From: publicaccess@cherwell-dc.gov.uk [<mailto:publicaccess@cherwell-dc.gov.uk>]
Sent: 07 July 2019 16:14
To: Linda Griffiths
Subject: Comments for Planning Application 19/00895/REM

Address: OS Parcels 6741 And 5426 West Of Cricket Field Nor Wykham Lane Bodicote

Proposal: Reserved matters to 15/01326/OUT - Layout, scale, appearance and landscaping for the residential development of up to 280 dwellings and 34 space car park.

Drawing file: 957-38-21 Rev A Adoptable Road Setting Out - Spine Road.pdf

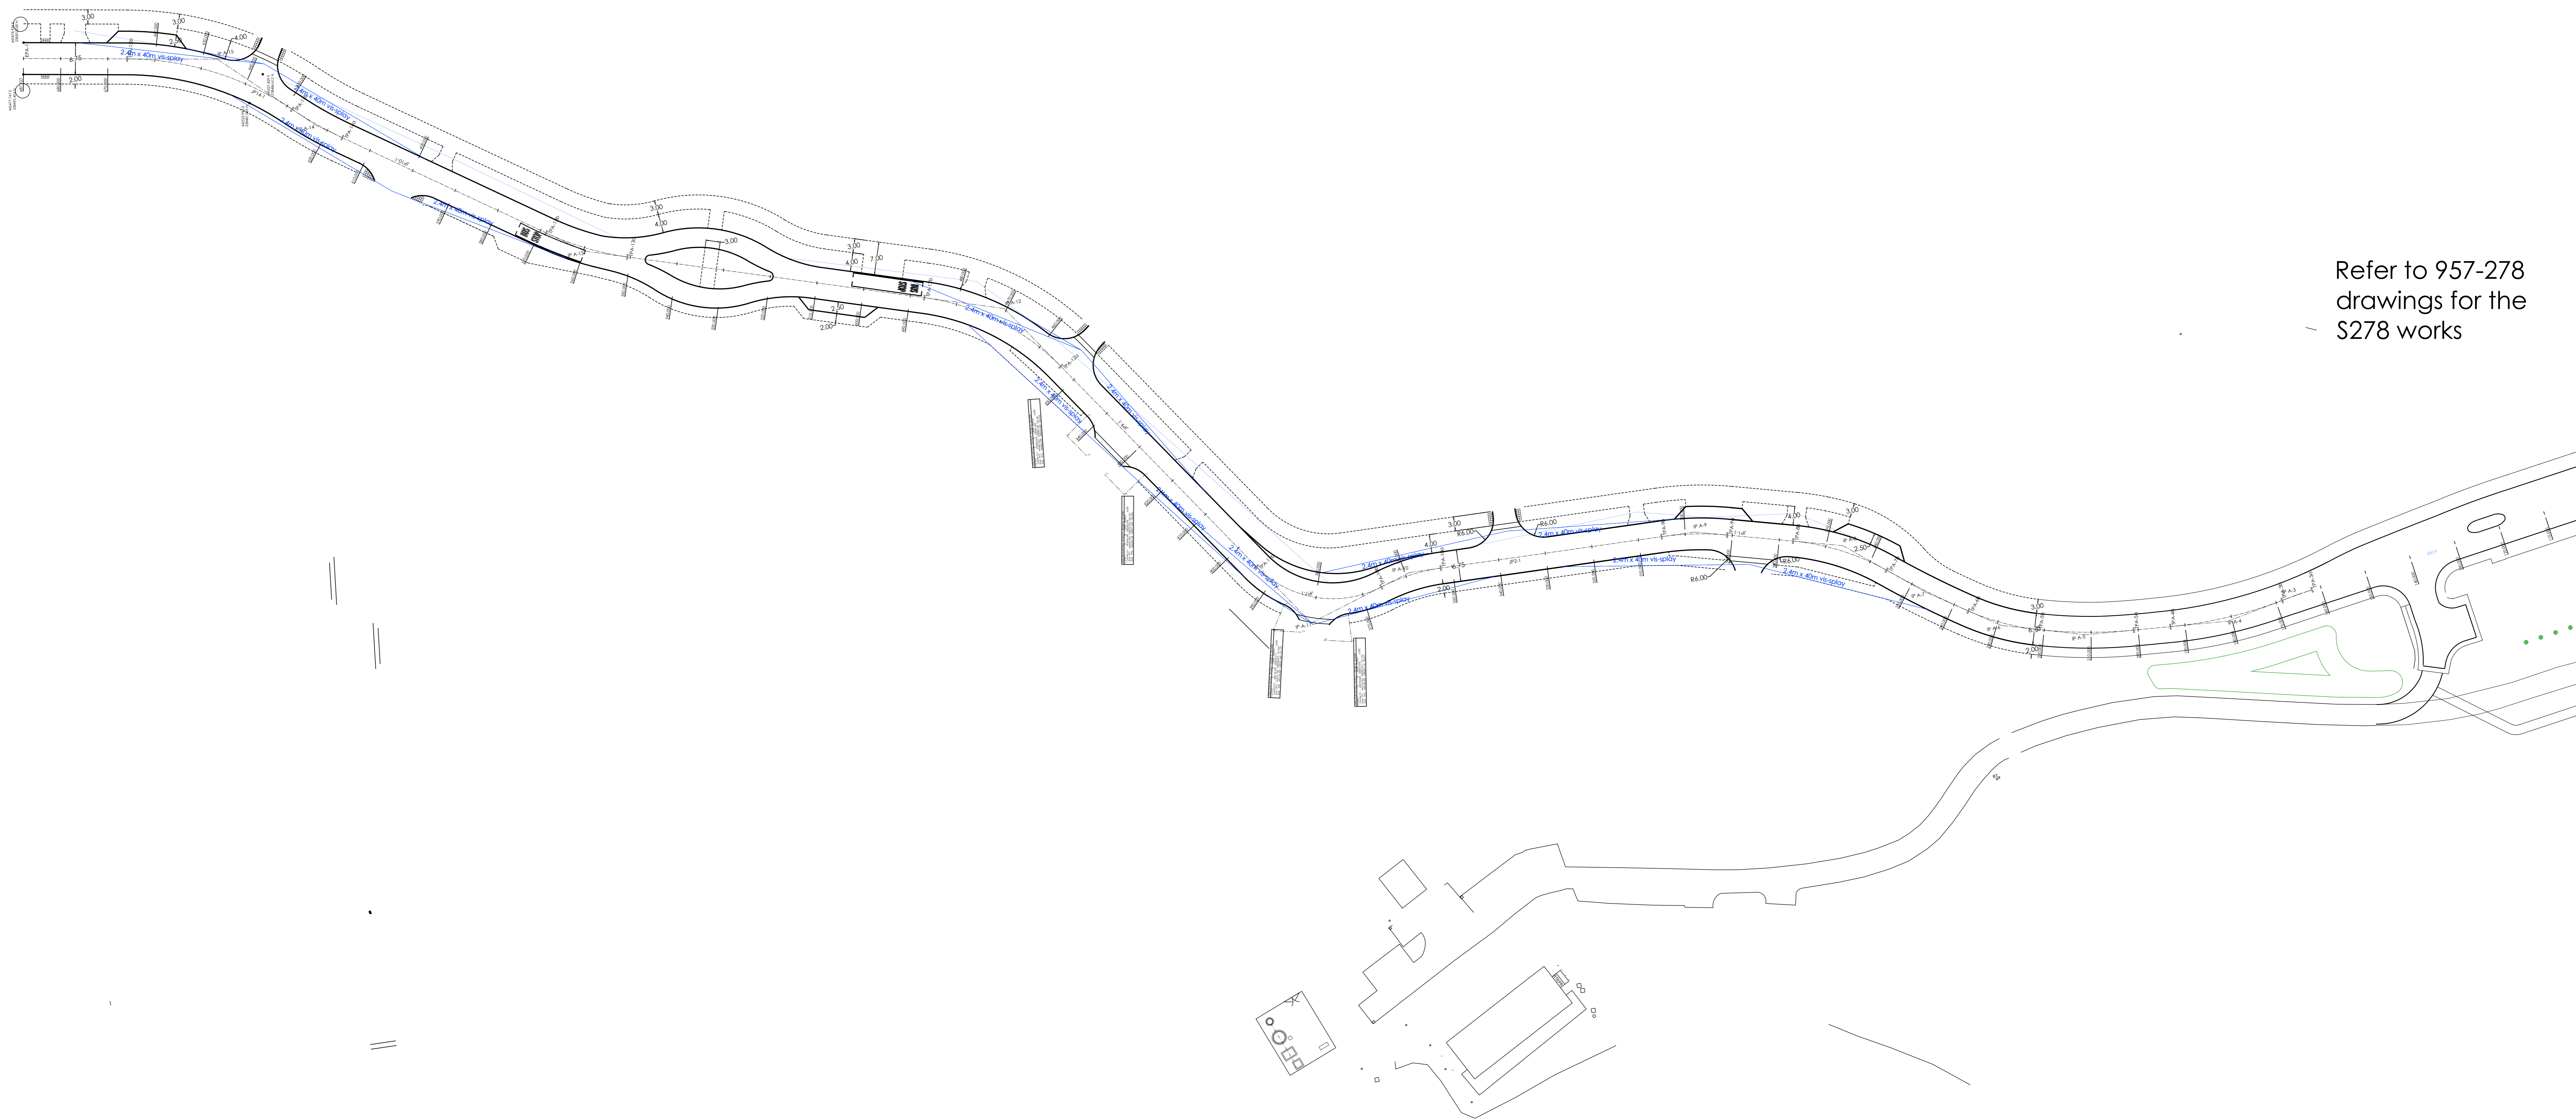
Comments: A number of points : -
1) Are 00895 and 01037 one and the same ? The documents listed appear to be identical.
2) On both numbers I have not been able to open Sheet 1 of the Indicative layout - the image is squashed to the top of the screen and is, therefore, illegible. This has happened before in a few cases. Can it be rectified, please ?
3)The sports areas have been moved form the positions shown back in 20 ?? Then the football pitches were alongside the Salt Way and provided a buffer between some of the houses and the naturalistic environment of the Way - also goal-keepers would not have the sun in their eyes from mid-day onwards. Sites near Salt Way and the spine road would be easier for visiting teams to find.
4) The spine road appears to be further east (closer to Salt Way) to that proposed earlier - can we be assured

that this will, indeed, align with the other section towards A 361, given that OCC have invested a lot of effort in designing the new roundabout at the A 361 junction.
